**KIRKLEES METROPOLITAN COUNCIL
INVESTMENT & REGENERATION SERVICE**

DELEGATED DECISION TO DETERMINE PLANNING APPLICATIONS

Reference No:	2025/62/91016/W
Site Address:	Fox House Farm, Moor Lane, Netherthong, Holmfirth, HD9 3UP
Description:	Installation of ground mounted solar panels (Listed Building)
Recommending Officer:	Molly Storer

DECISION – CONDITIONAL FULL PERMISSION

Drg. no.	Rev.
283-24-PL01	C

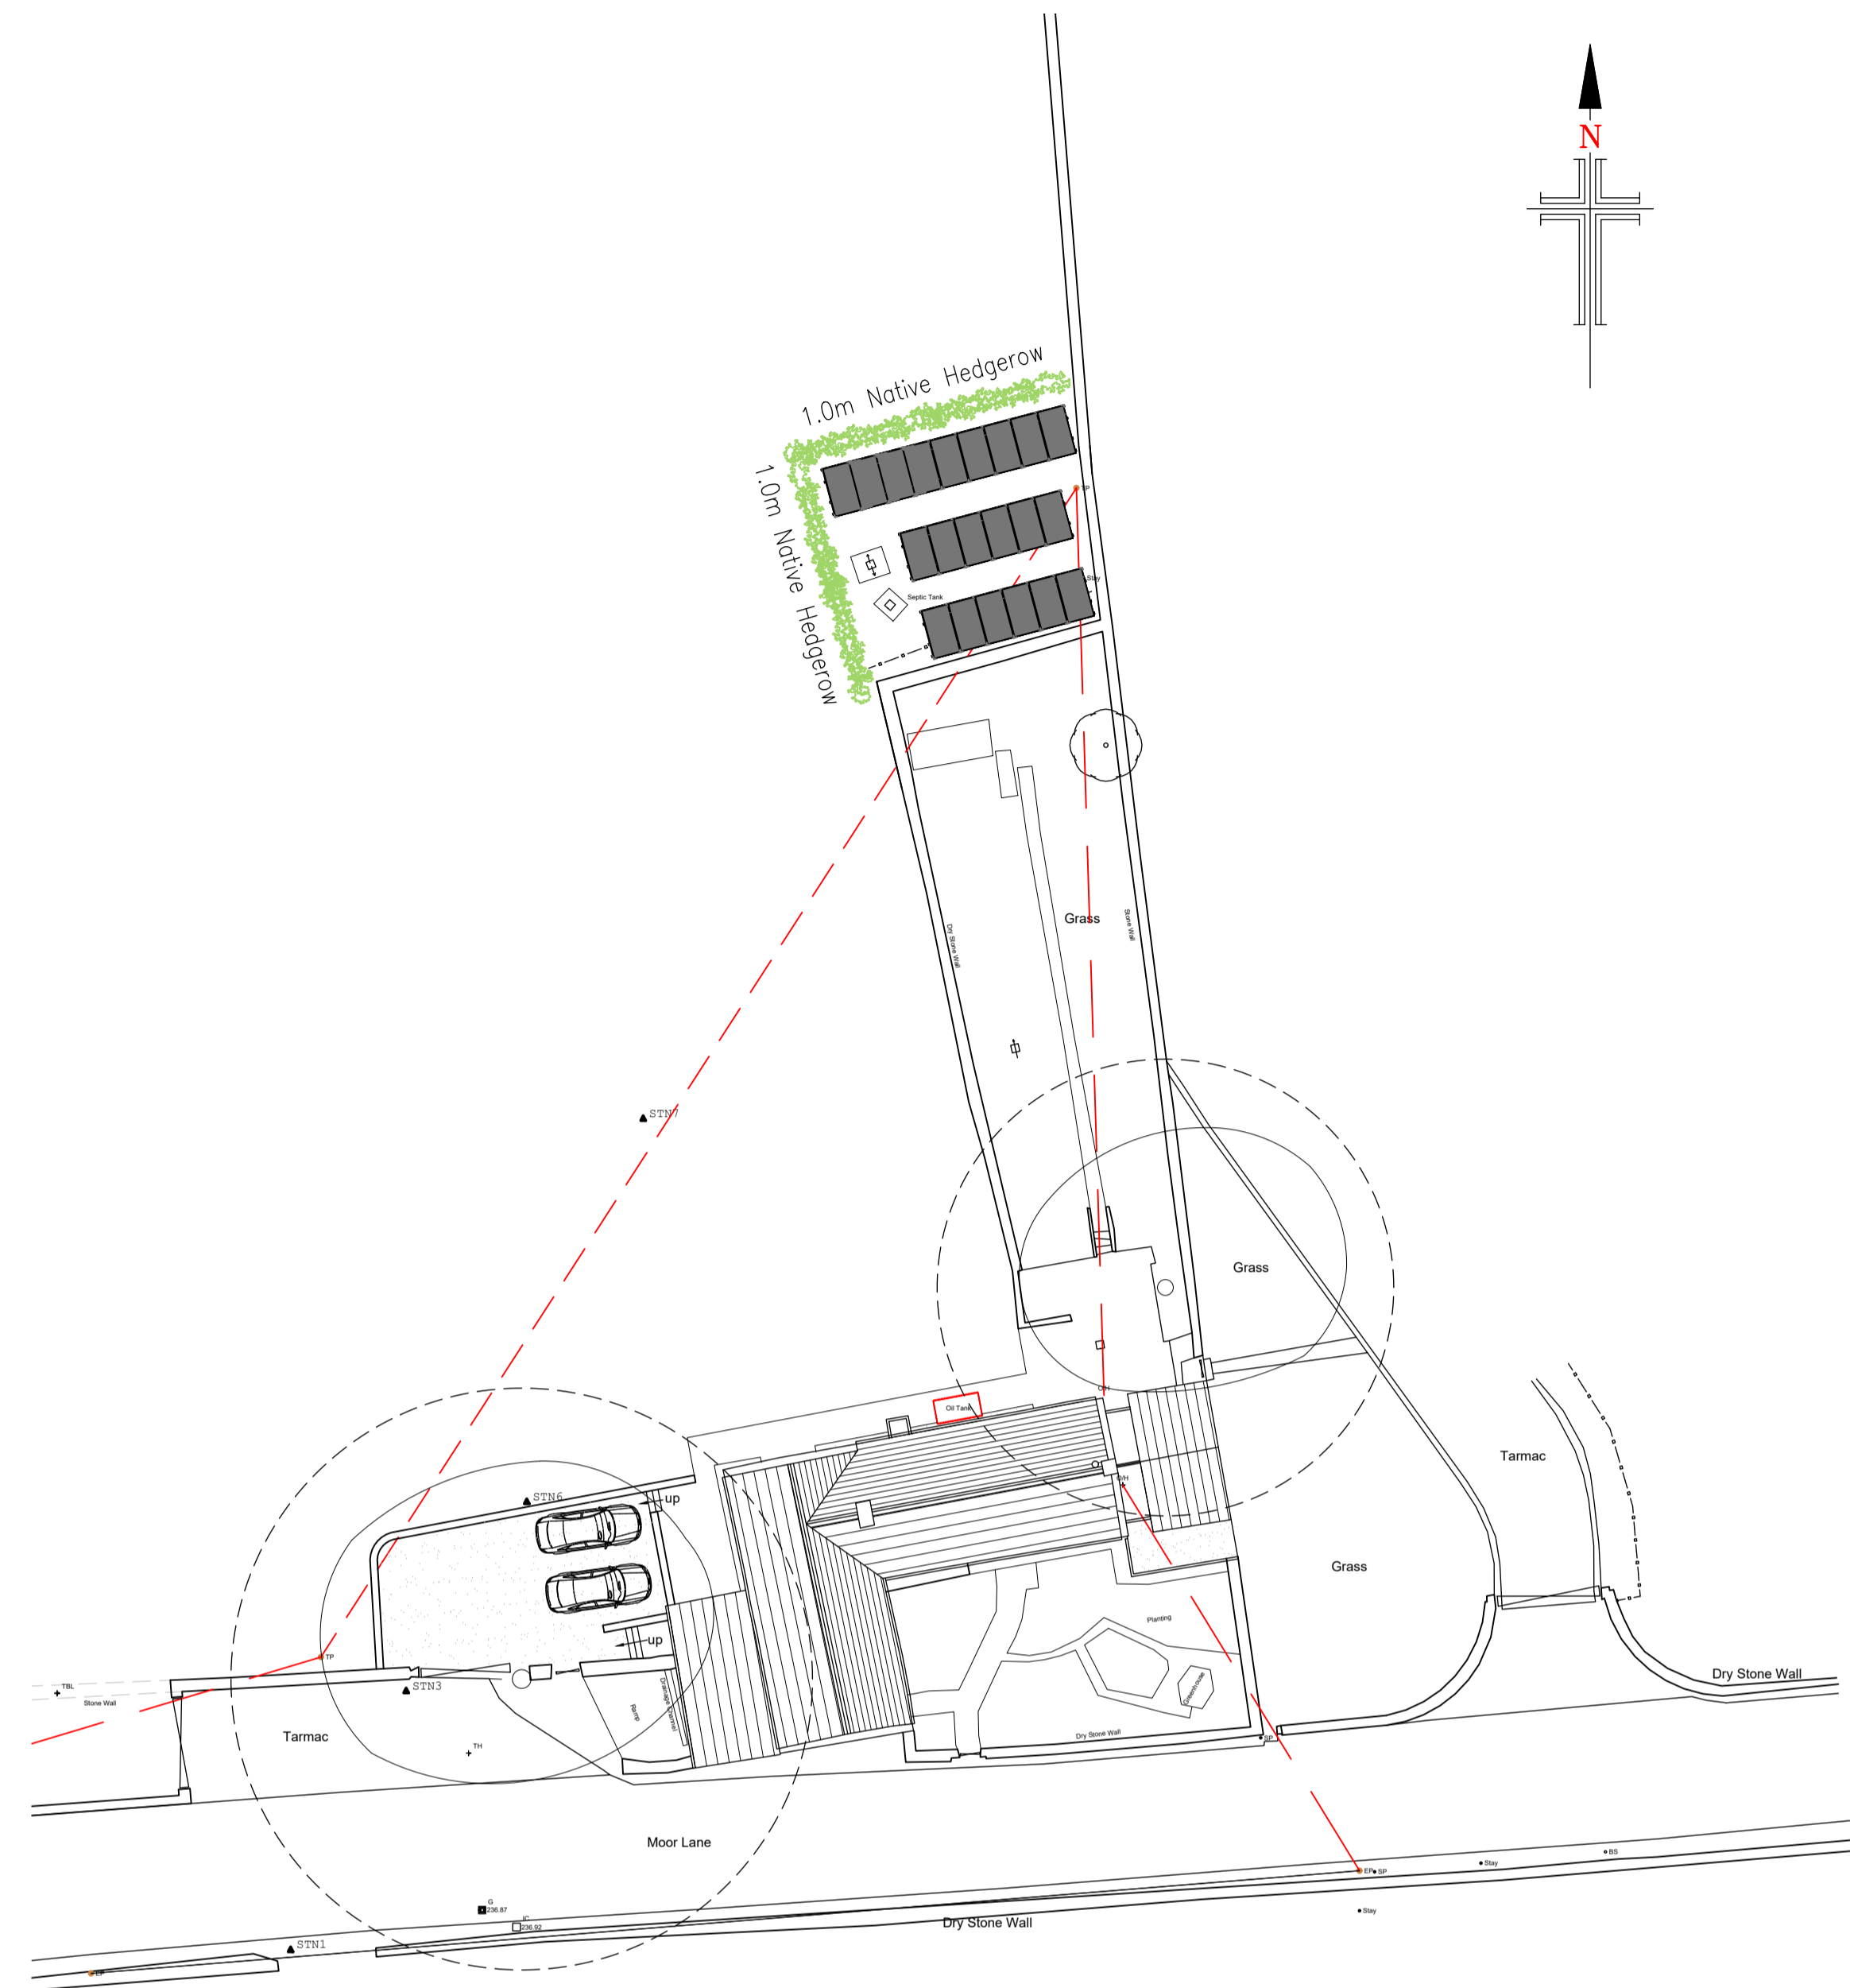
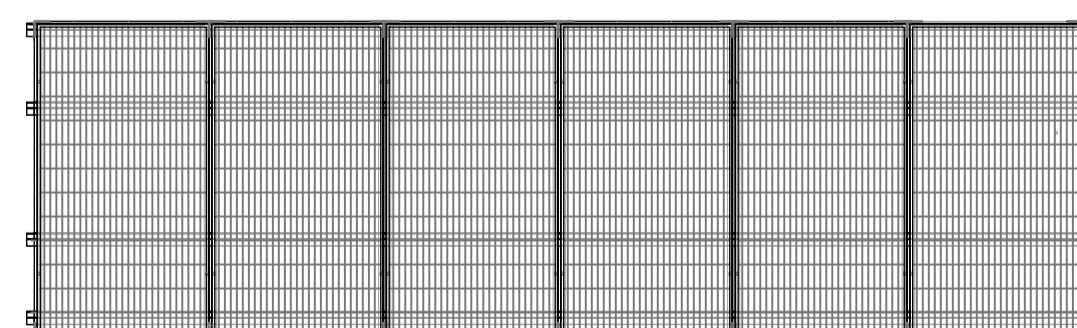
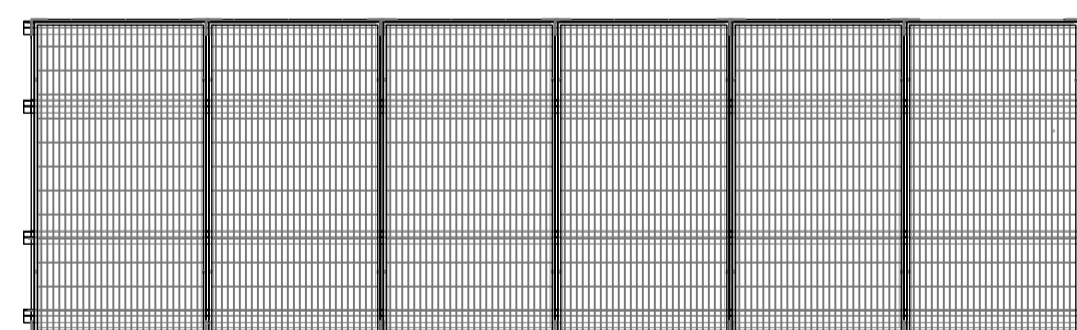
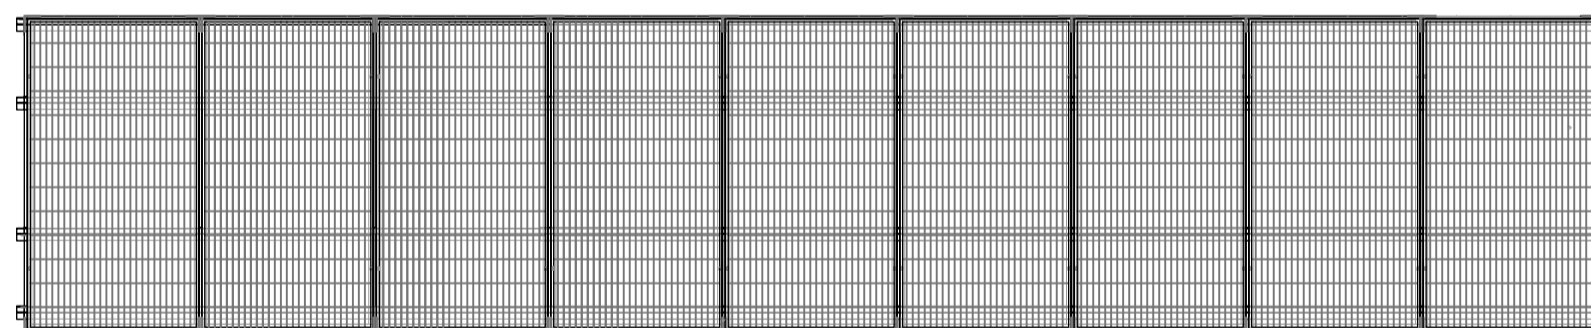
The agent was contacted following discussions with conservation officers. It was noted that the plans state there will be a wire fence surrounding the solar panels however officers suggested that instead a low native hedge surrounds the panels in order to protect the character of the setting of the Listed Building. The agent agreed to this. It was also suggested that conditions be attached to any grant of permission to ensure that the solar panels are to be constructed using black glass and black frames. The agent also agreed to this.

Following concerns about the Green Belt final amended plans were sent which showed the proposed area that the panels previously occupied reduced and positioned closer to the existing boundary treatment forming the properties domestic curtilage. Boundary treatment is shown in the form of native hedgerows. In addition, additional information was sent outlining the solar 'system performance' calculations.

However, there were still concerns that the proposal would constitute inappropriate development in the Green Belt. The agent was contacted due to concerns that the siting, outside of the domestic curtilage of Fox House Farm. Subsequently amendments to the scheme to limit the impact to the openness and factors considered to constitute very special circumstances have been detailed.

Amended plans demonstrate the proposed area that the panels previously occupied reduced and positioned closer to the existing boundary treatment forming the properties domestic curtilage. Boundary treatment is shown in the form of native hedgerows. In addition, additional information was sent outlining the solar 'system performance' calculations. It states that on average a detached dwelling will utilise 3,500 kWh of electricity per annum. The proposed solar array will generate 7,654 kWh, this resulting in 100% surplus that will be returned into the power grid. It is considered that the proposed panels will provide a wider benefit than just to the application property. In addition, the solar array will provide increased production of sustainable energy which will provide wider environmental benefits.

3. Notwithstanding the plans submitted the solar panels shall not be brought into use until enclosed with soft landscaping consisting of a native hedge in the location annotated '1.0m Native hedgerow' upon drawing PL01RevC which shall be retained thereafter.
